**Proposed Care Home Development
Boothroyd Lane, Dewsbury
Transport Statement**

December 2025

Job No:	LTP/25/6695	File Ref:	Boothroyd Lane Care Facility TS Final Issue 1
---------	-------------	-----------	---

DWG. NO: 1362
REV. 02
REV. E

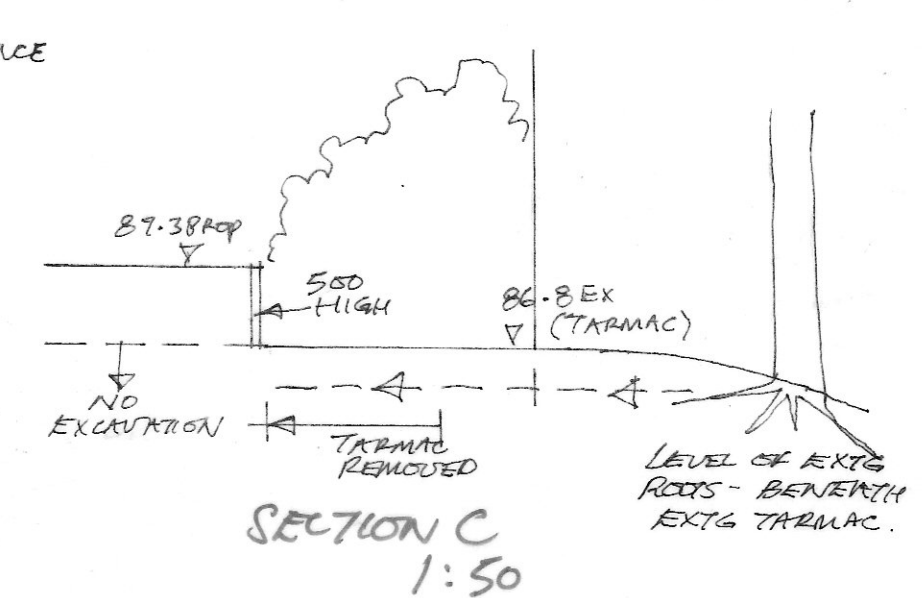
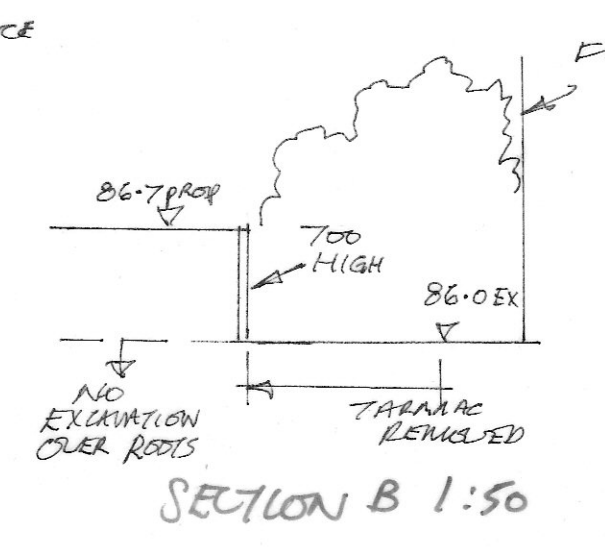
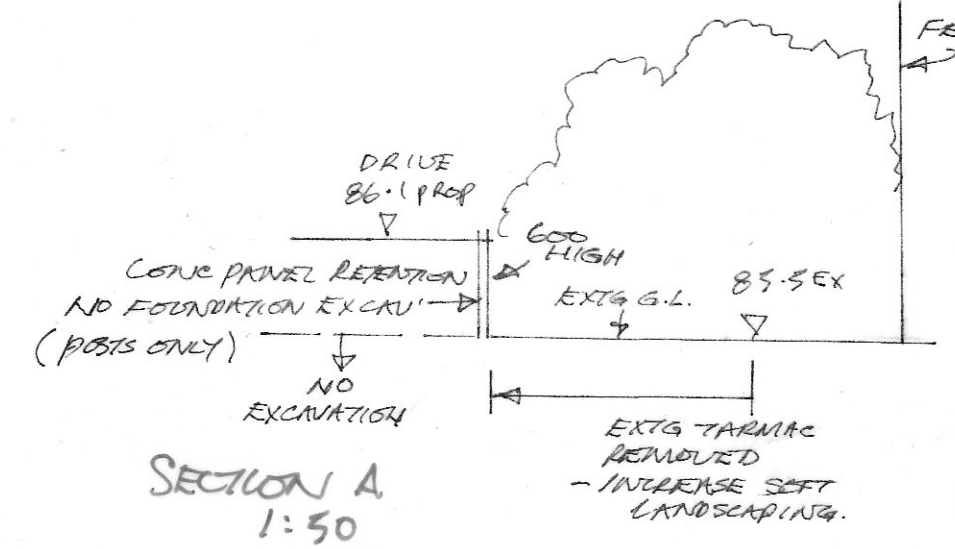
Drawing No 1362 01 Rev A (indicatively, by means of grey shading) shows improvements to the access with a new kerbed radius and an increase in width to approximately 5m with a 2m footway connecting into the existing footway on the eastern side of Boothroyd Lane. It is considered probable that visibility splays based on Manual for Street calculations can be achieved. For a 30mph road these should be 2.4m x 43m, however the Y-distance may be shortened if speed survey evidence can be provided. All visibility splays should contain no obstructions to visibility above 1m in height (which could be conditioned in the event of a future approval).”

“Details of how the new 2m footway will be tied-in with the existing footway to the east side of Boothroyd Lane would also need to be provided in support of a future application.”

“The drawing states that the wall alongside the western boundary of the site is a “Stone Retaining Wall”, if this is a retaining wall then any changes to may require a technical Approval In Principle from the Council acting as Highway Authority. Such an application is usually made subsequent to the grant of planning permission.”

LTP Response – It is noted that the wall currently restricts visibility to the right of the access, but a section of this wall is proposed to be removed in order to facilitate the improved access arrangements and 2m footway, as detailed further in Section 2.3.

LTP Response – The footway connection has now been indicated in the site plan provided as Appendix 1.

LTP Response – Noted.
